October 26, 2011

**Re: Spectrum Assisted Living Drainage Report and Grading and Drainage Plan
Engineer's Stamp dated 10-12-11 (A12/D025)**

PROJECT TITLE: Spectrum Assisted Living Facility
DRB #: 1008528 EPC #: 11EPC-40040/40041

PROPOSED DRAINAGE BASINS

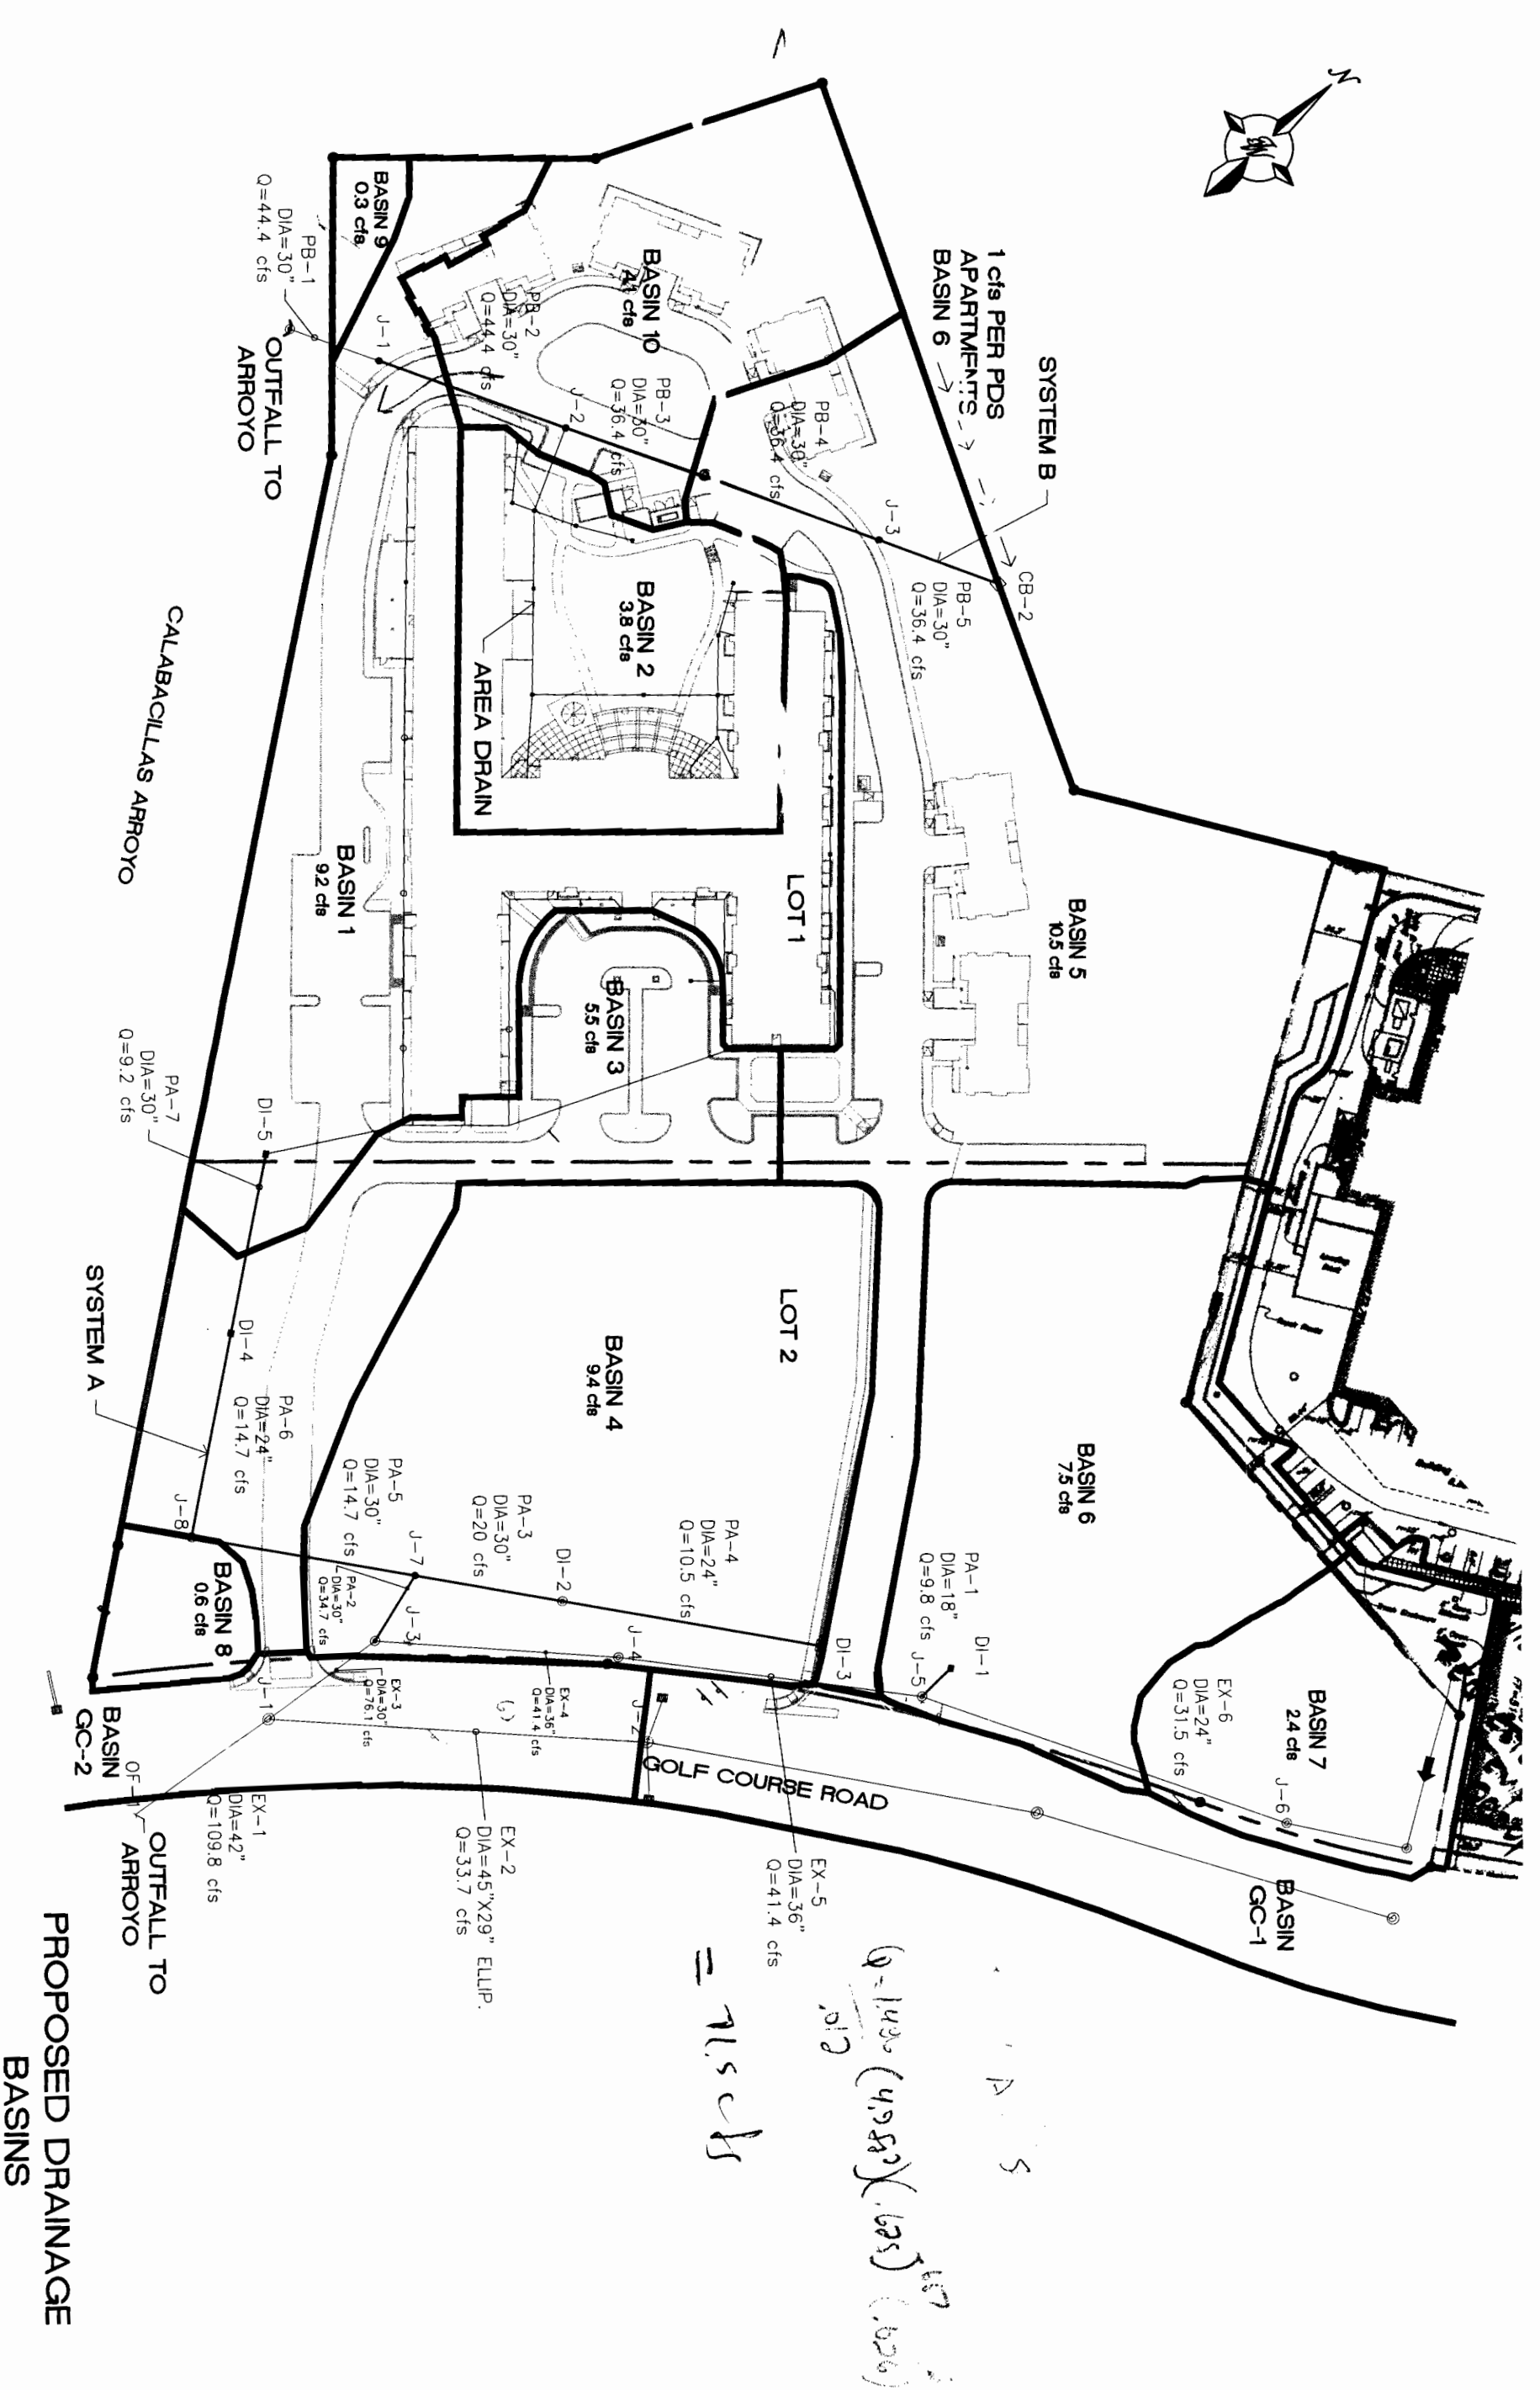
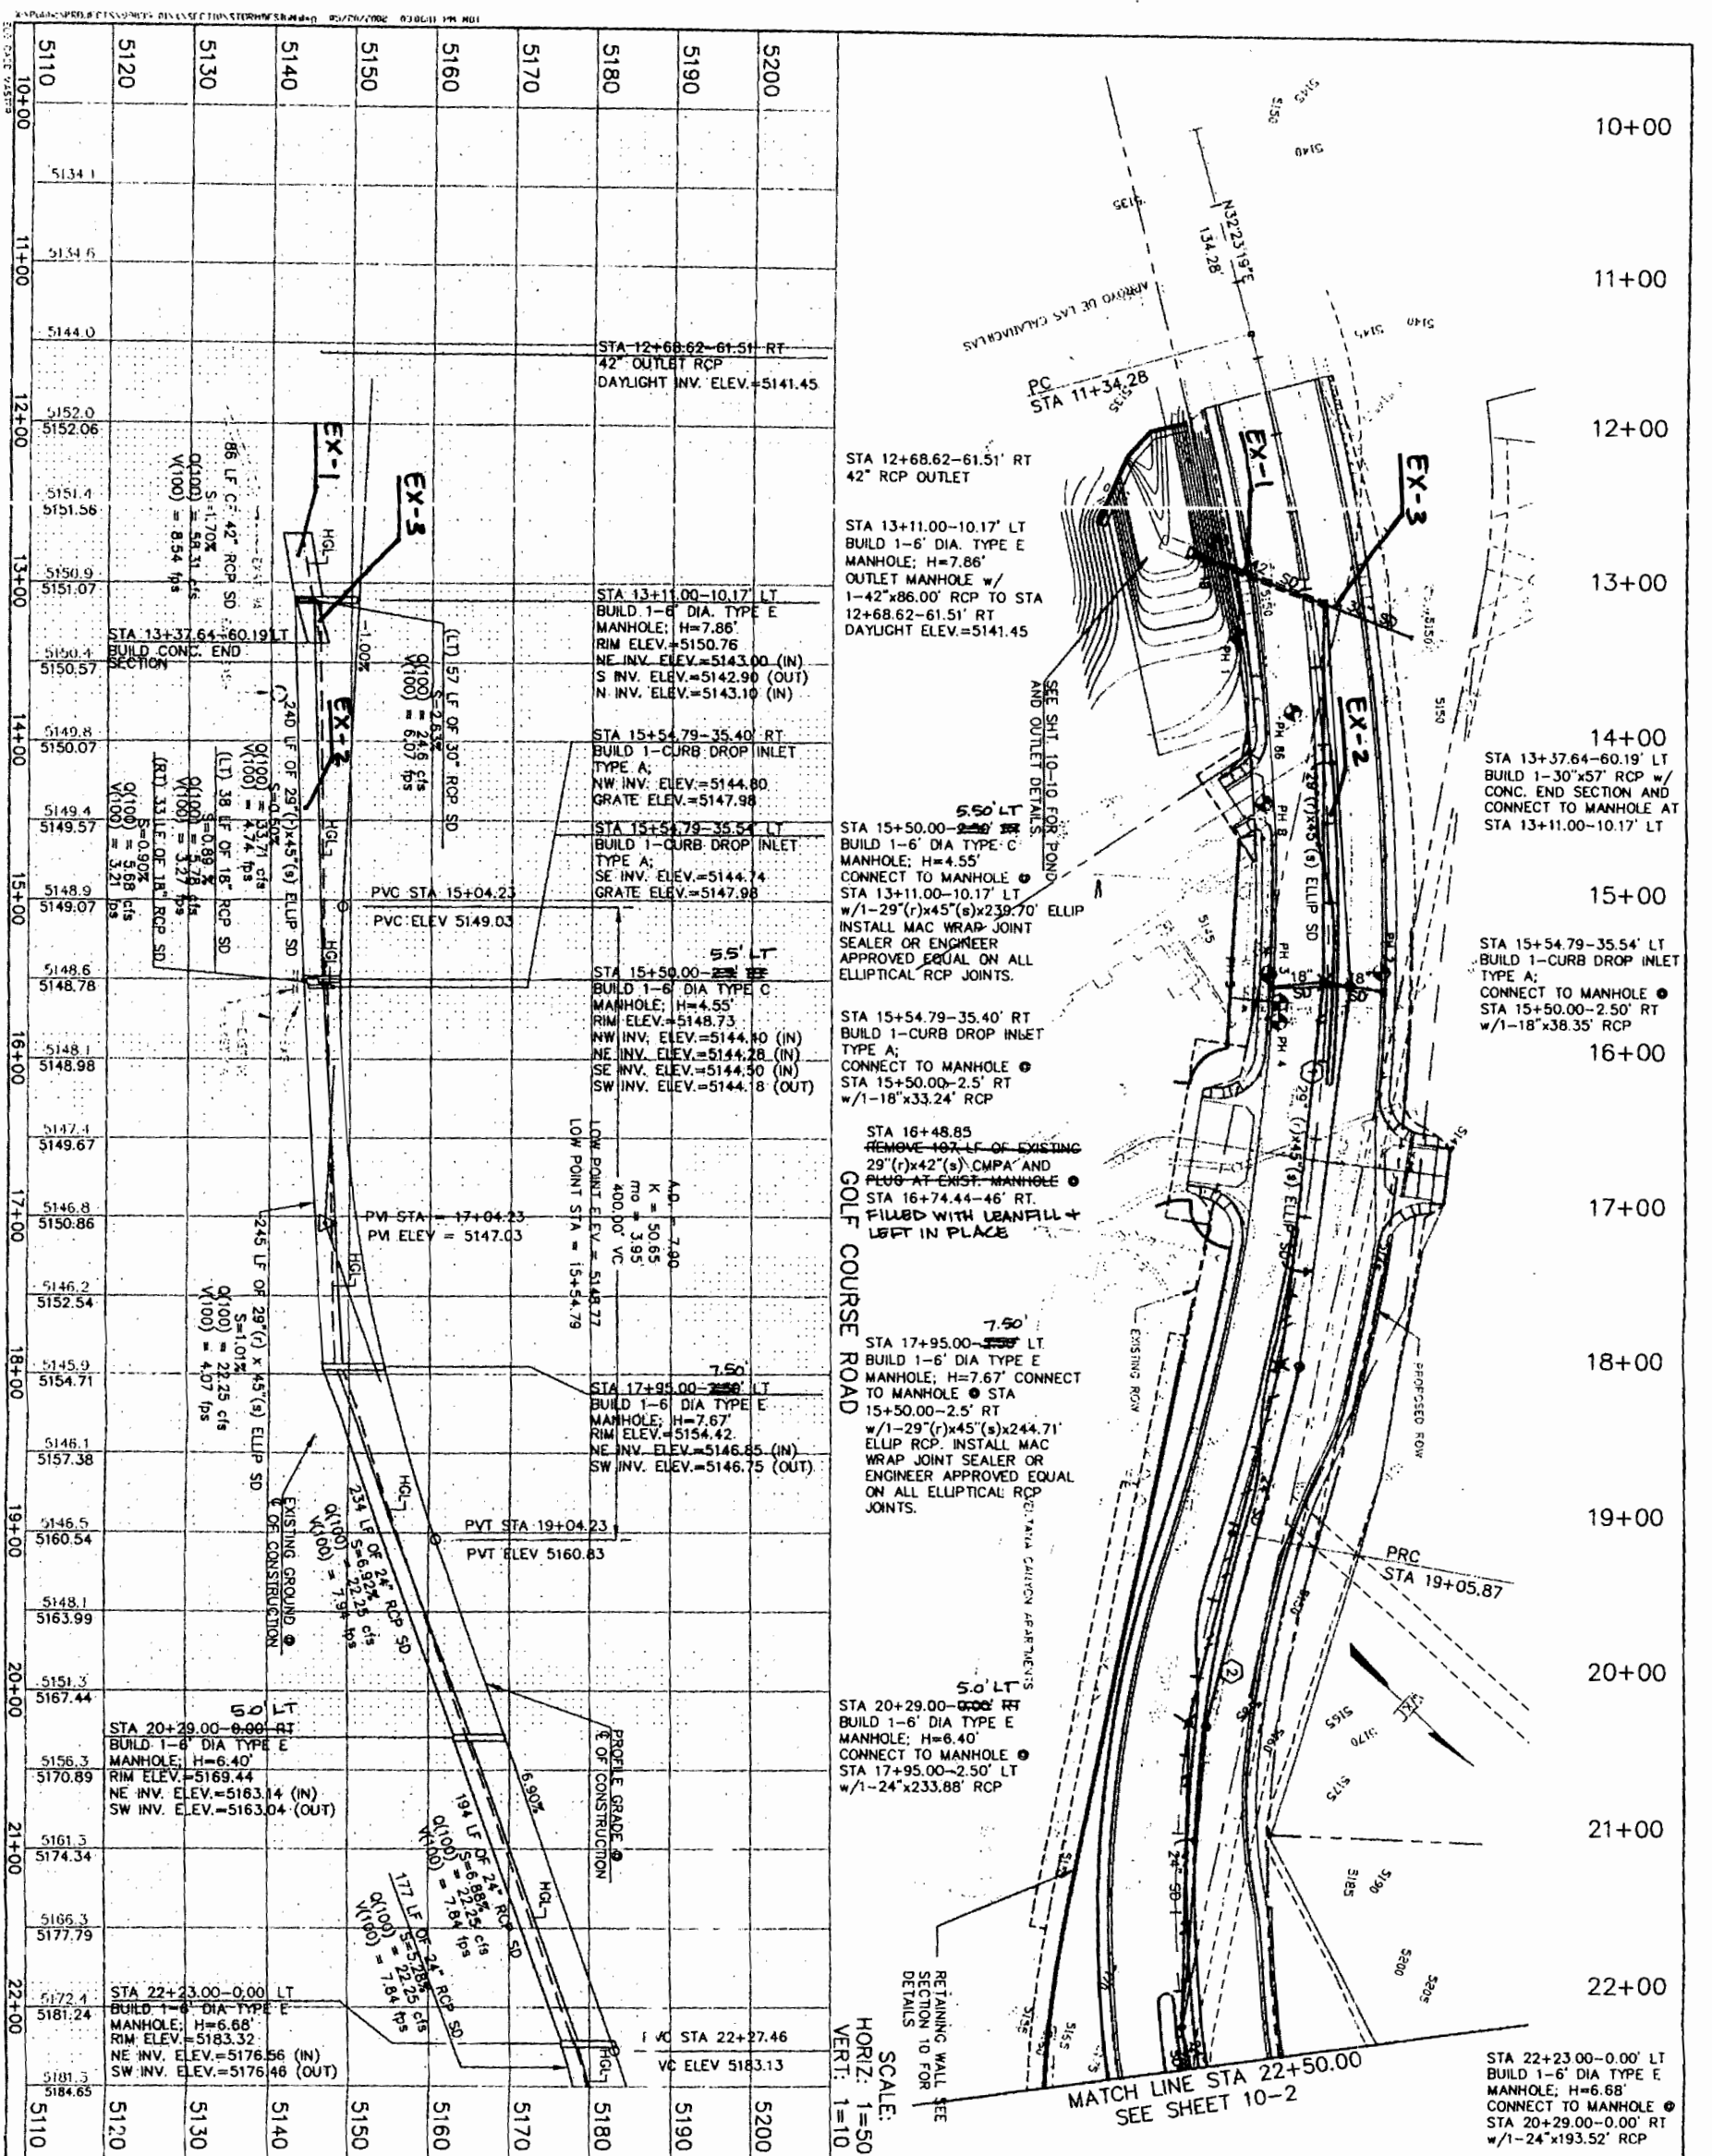
- On the "Worksheet of Area Drain Lateral..." which pipe label/segment does this pertain to?
- Hydrology cannot determine if the storm drain under Golf Course road has the capacity for the runoff from this site.

- The report states "No offsite flows discharge onto the site. It appears that Lot 24 of Palomas del Sol, the portion of the Smith's site south of the curb, and a small portion (1 cfs) of roof drainage from Sub-Basin 6 of the Puerto del Sol apartments drains into this site and should be accommodated."

- Lot 1 and Lot 2 are mentioned on Page 7 but not shown on the Conceptual Grading and Drainage Plan.
- Golf Course Road contributes flows to the storm drain system. It should be shown as a basin.

Profile - 2 - Base

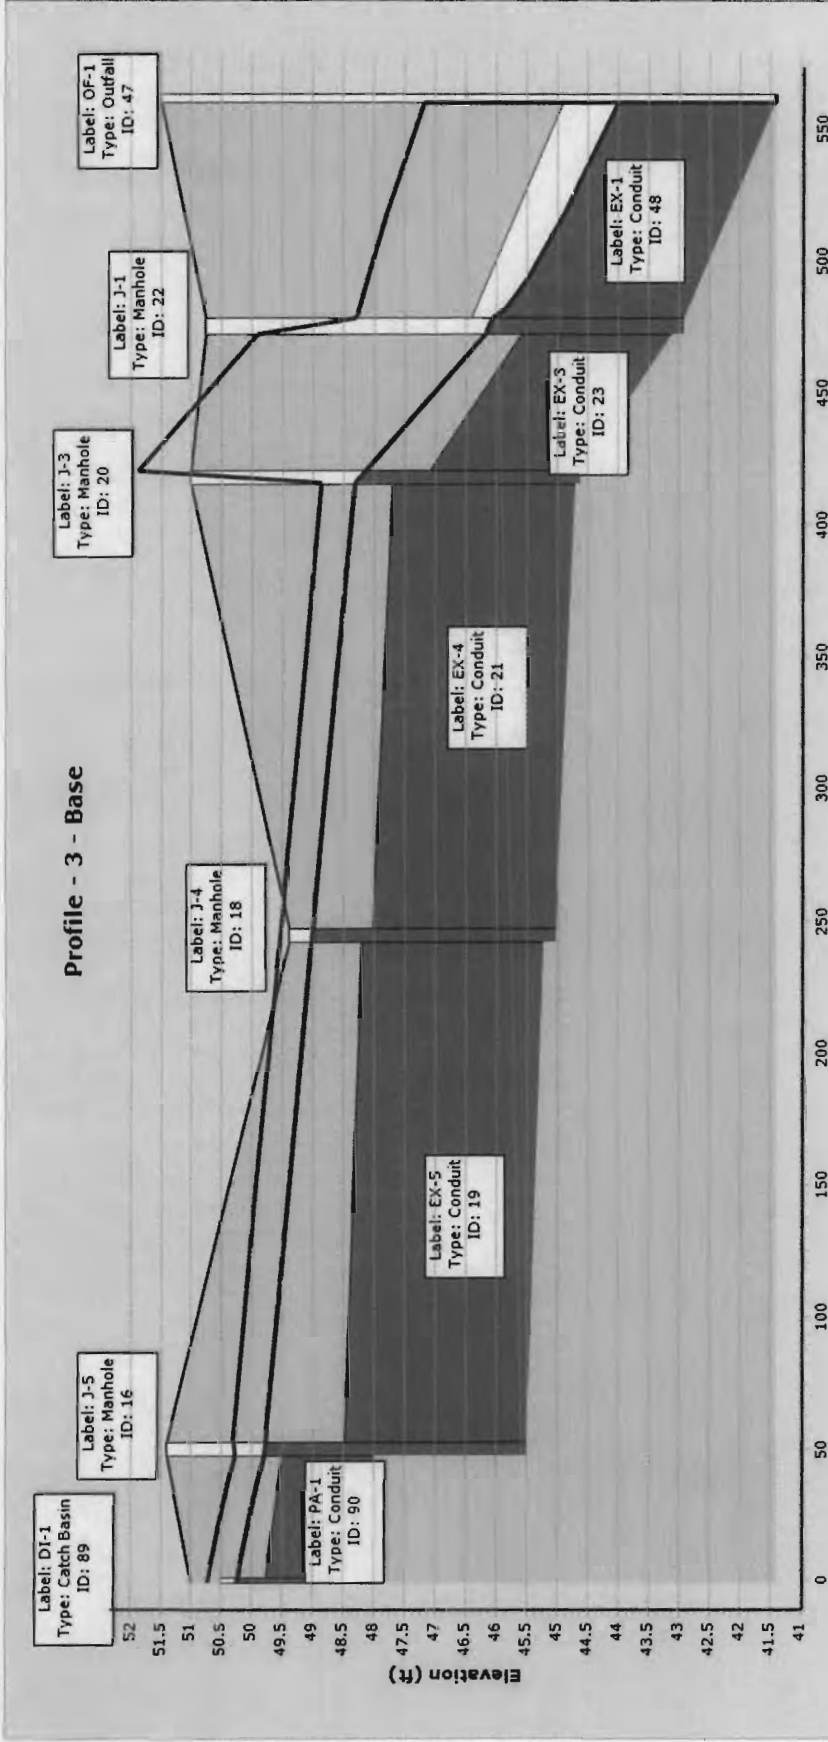
- In the SYSTEM 1 table, numerous downstream inverts are higher than the upstream invert.
- On the second Profile -1-Base sheet, the pipe labels do not correspond with anything in the table or "Scenario" sheet.
